AL/72/22/PL

Rock House Westergate Street Westergate PO20 3RJ

Demolition of Servac Int workshops keeping certain structures and features, to renovate them in to a 2 No carport, with storage loft and re-landscaping to provide new gardens and biodiversity zones.

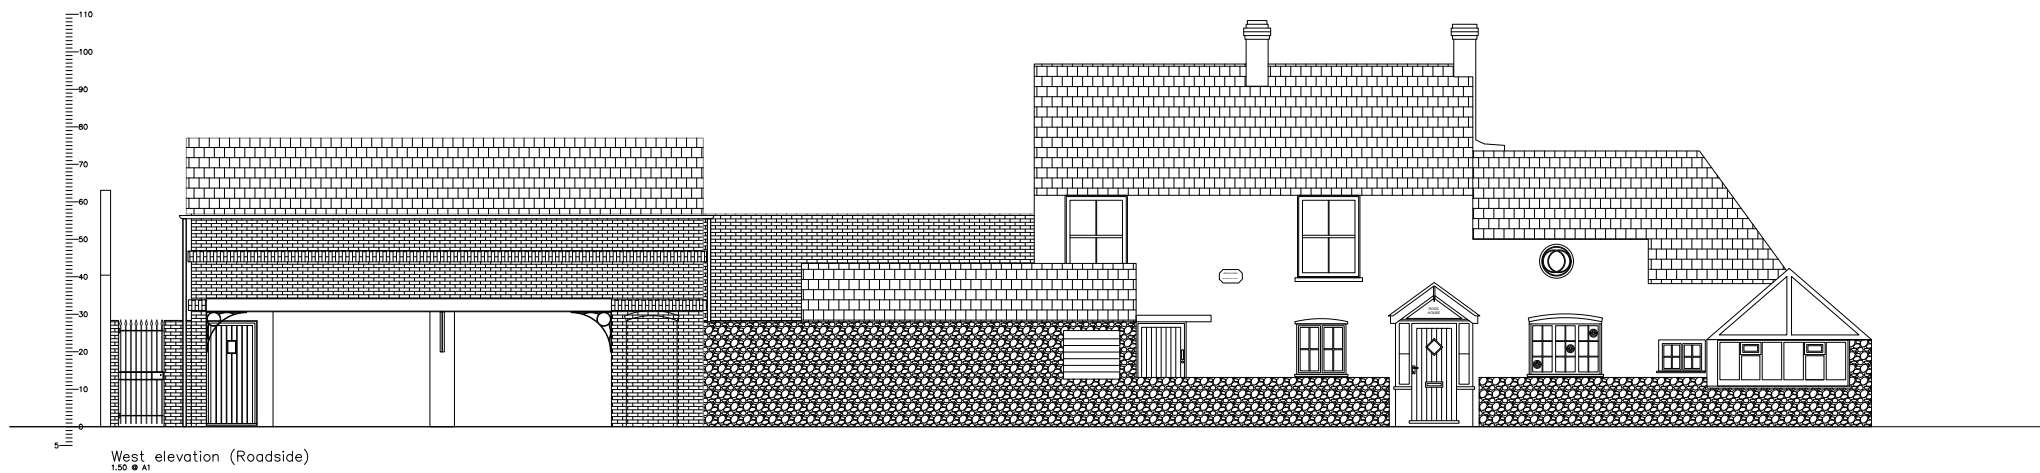
Whilst the design does have some positive elements, the use of the roof space as storage will mean that the building will be higher than it could be if this space was not included. The storage space will cover a large floor space area and could be put into an alternative use in the future. This increase in height will mean that it will be seen not only in the context of Rock House (so that it is not really subservient to it), but also the side elevation of the listed building. Its sheer height will mean that the

eye will be drawn to it when viewing the two buildings from the surrounding roads. This element is therefore problematical, and not acceptable.

West elevation - Roadside
1:50 @ A1

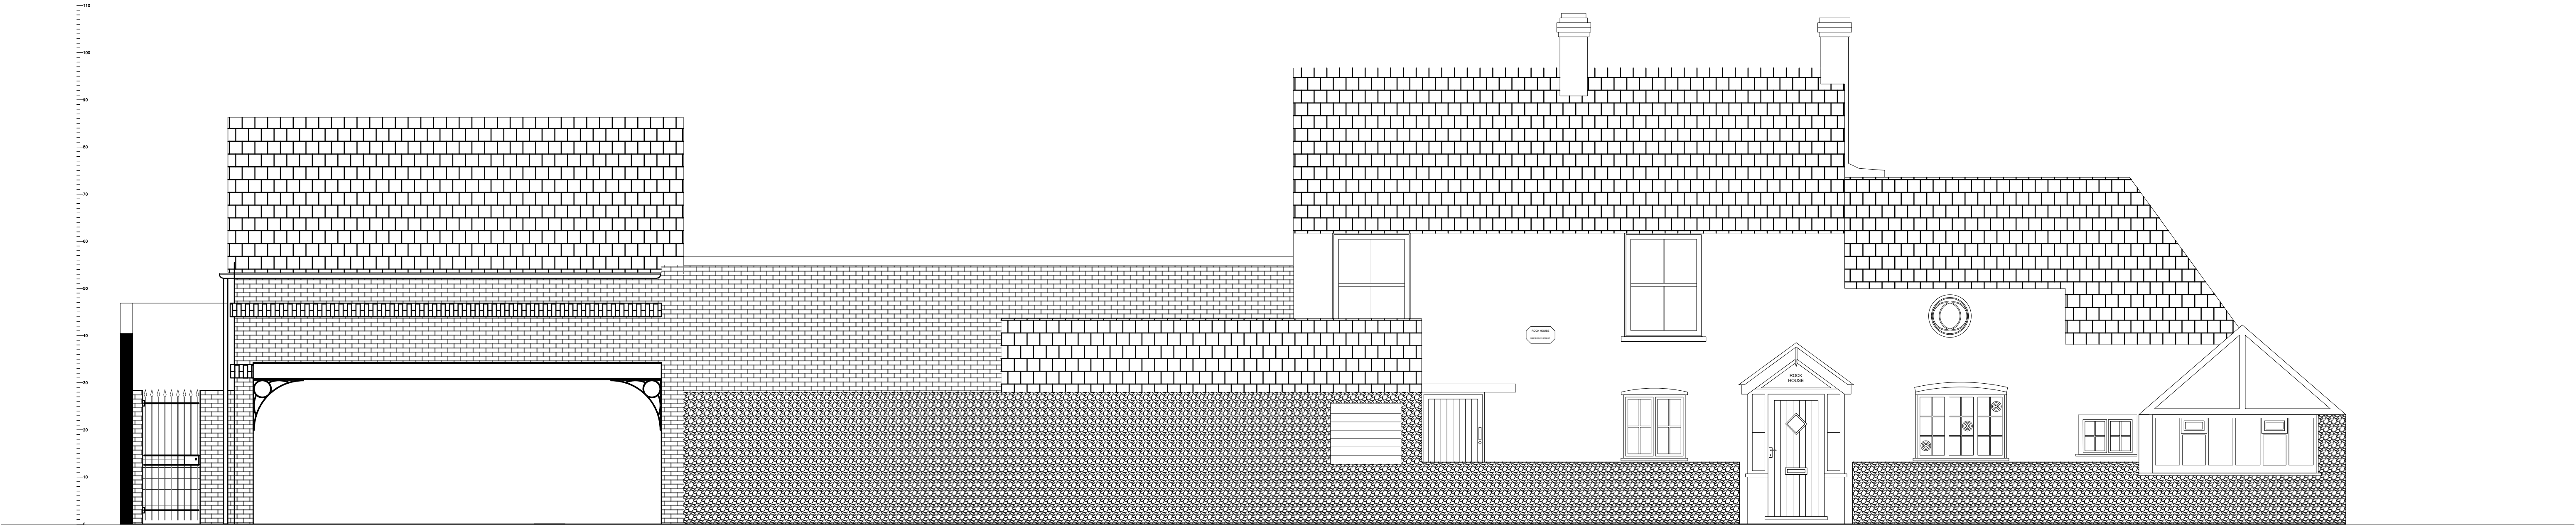
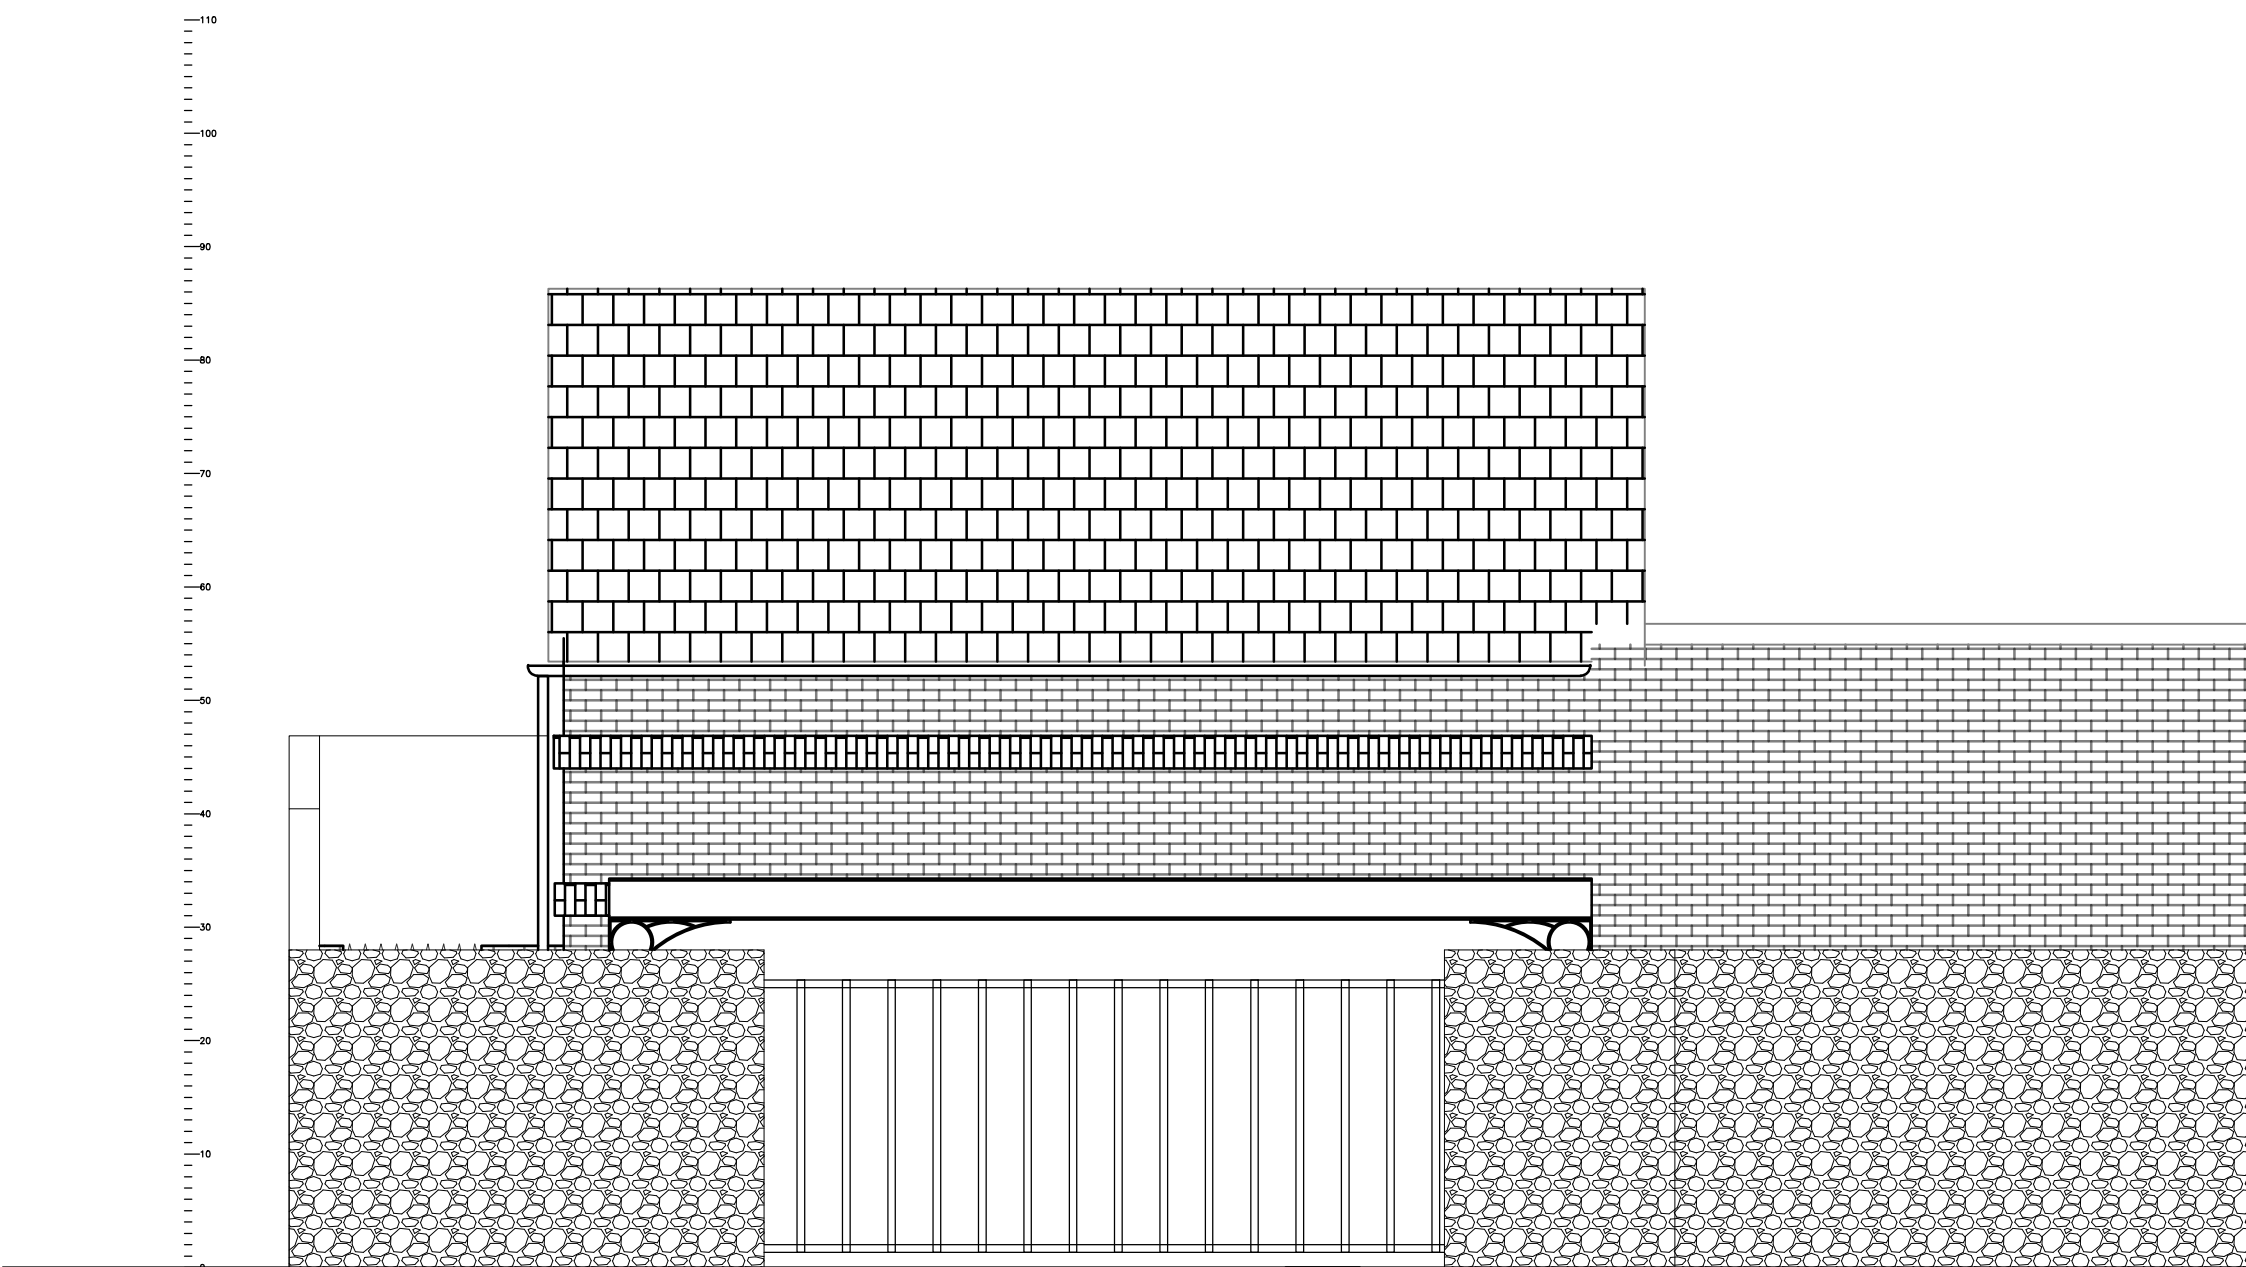
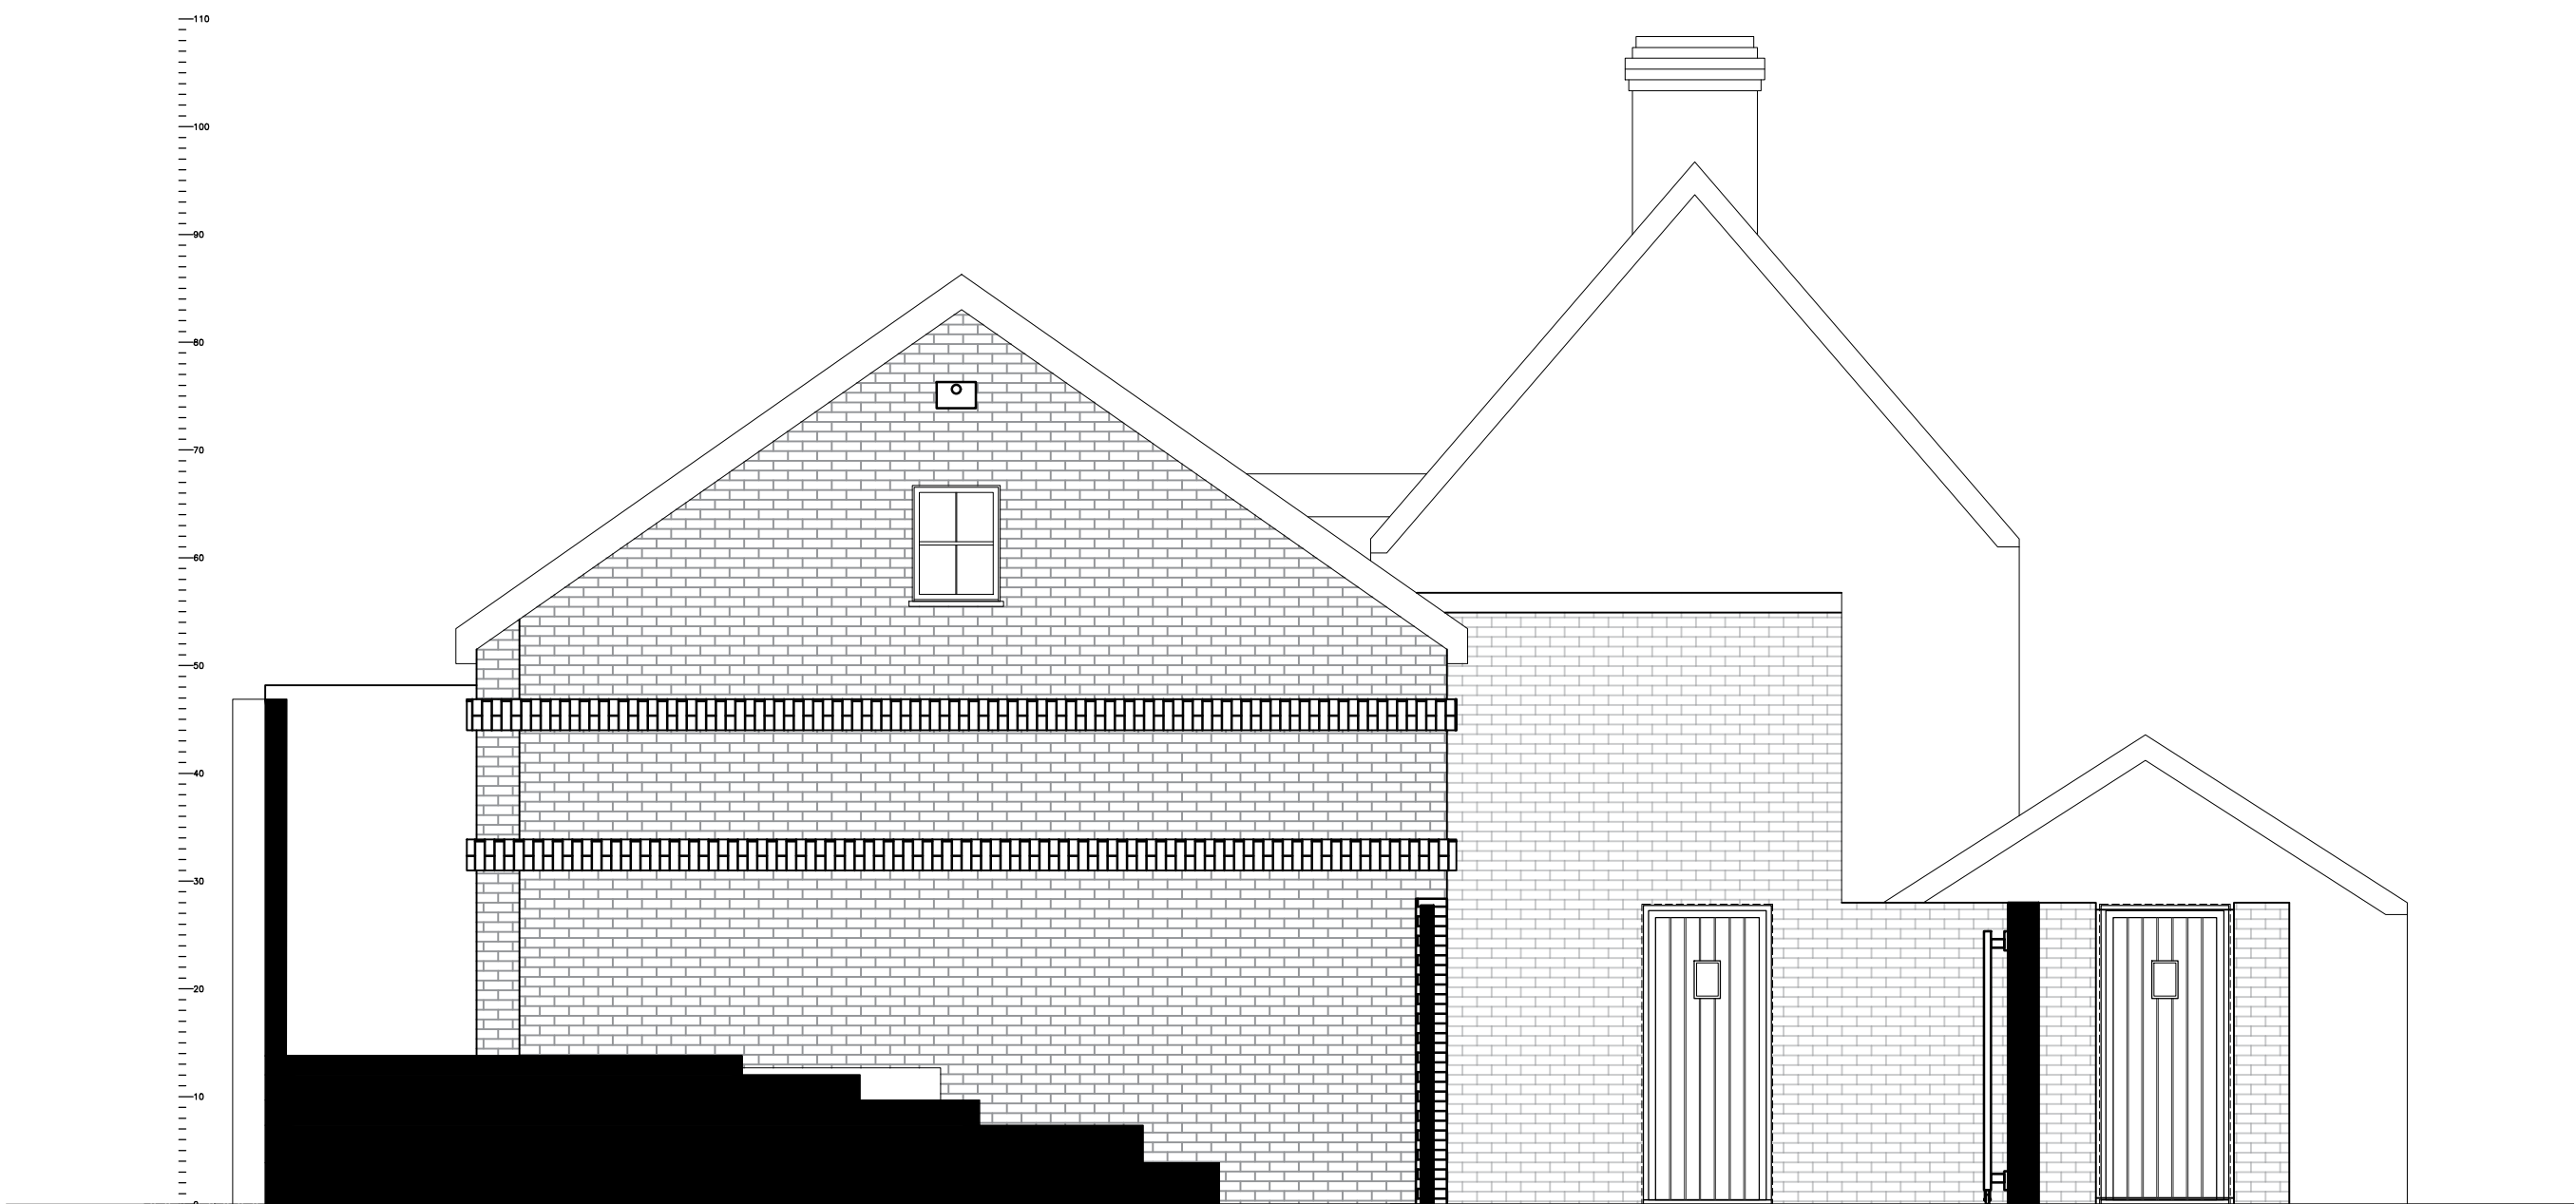
Point to note: The plans titles 'west elevation – roadside' appears to show that the proposed gate will cover the majority of the frontage of the car port with a small stretch of wall to the left hand side, whereas the ground floor plan implies that the same opening will cover the width of what is identified as 'car port 1', with a much larger stretch of wall. Which is correct?
